December 5, 2000

RE: Zanios Food Warehouse Addition Phase III Grading & Drainage Plan (K10/D21A)

Attached is the revised Grading & Drainage Plan for the Zanios Addition. The orifice modification calculations have been added to the plan.

C-1

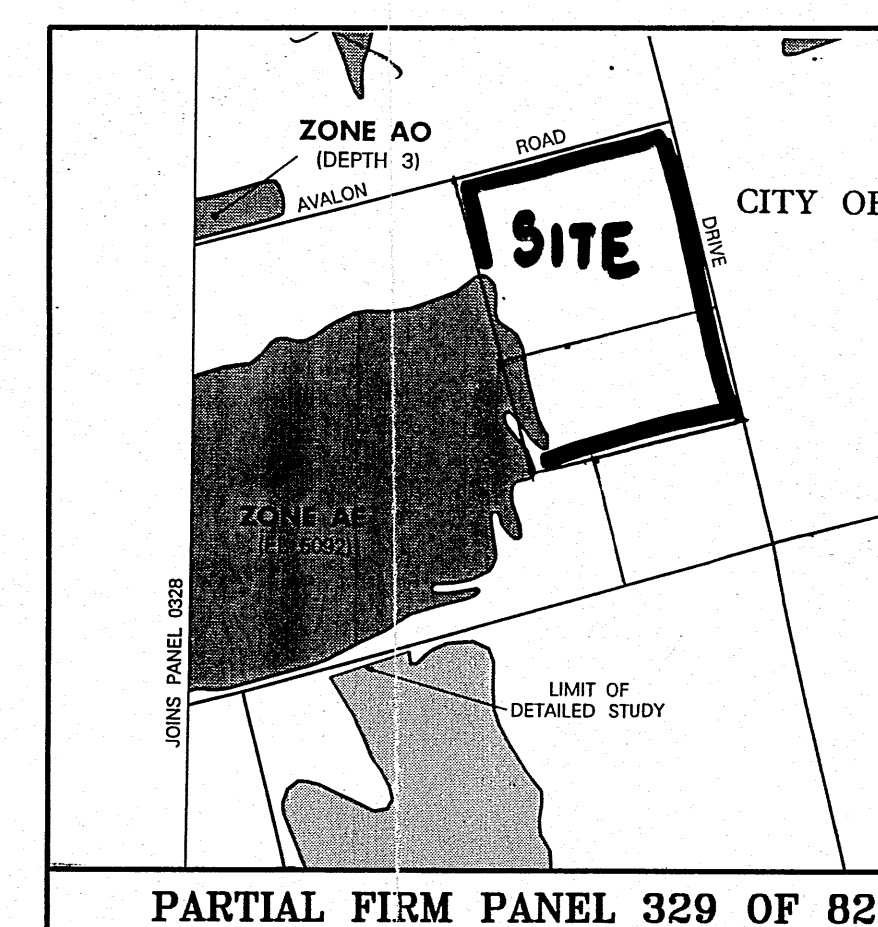
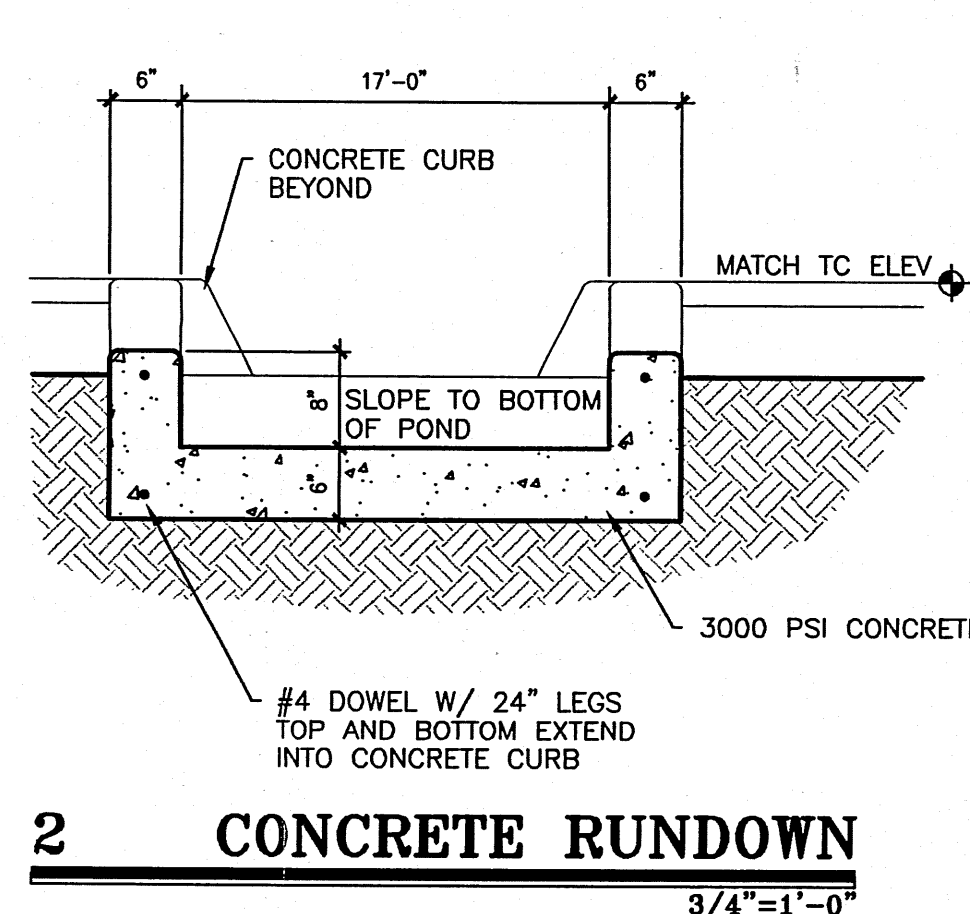
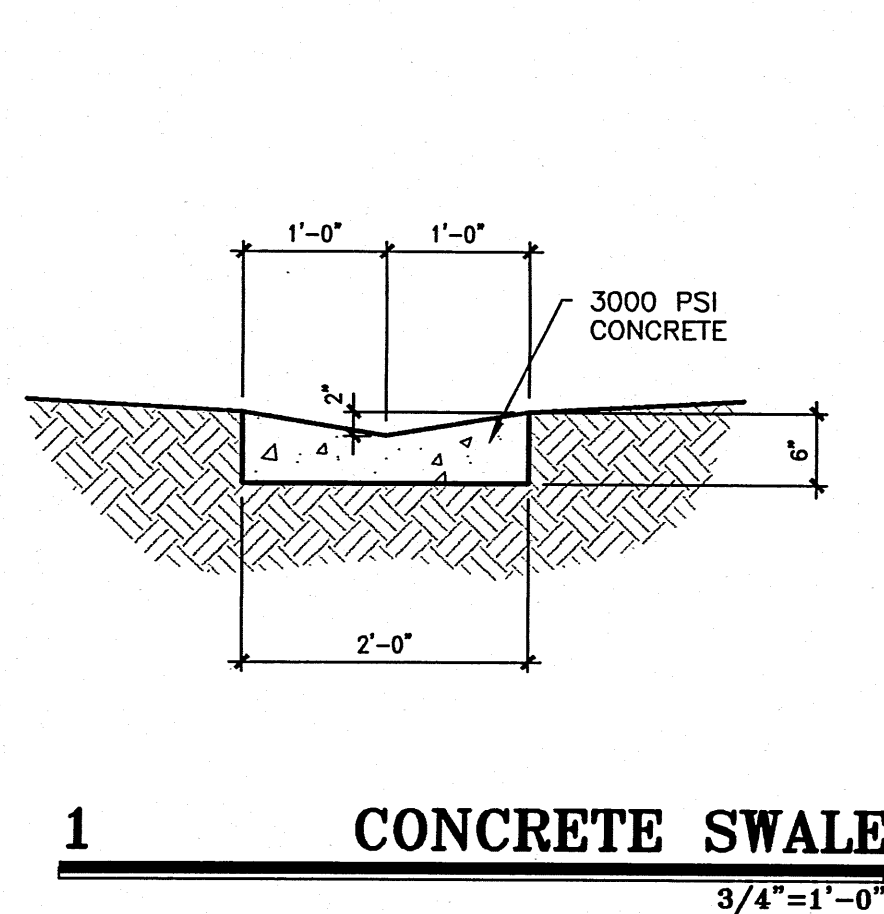
Per our discussion pipe bollards have been added at the concrete rundown. The bollards will be set 10 feet apart to allow for maintenance

The proposed surface for the new fire lane is gravel and has been noted on the plan.

The retaining wall for the slab at the southeast corner is part of the building foundation as is the retaining wall for the loading docks.
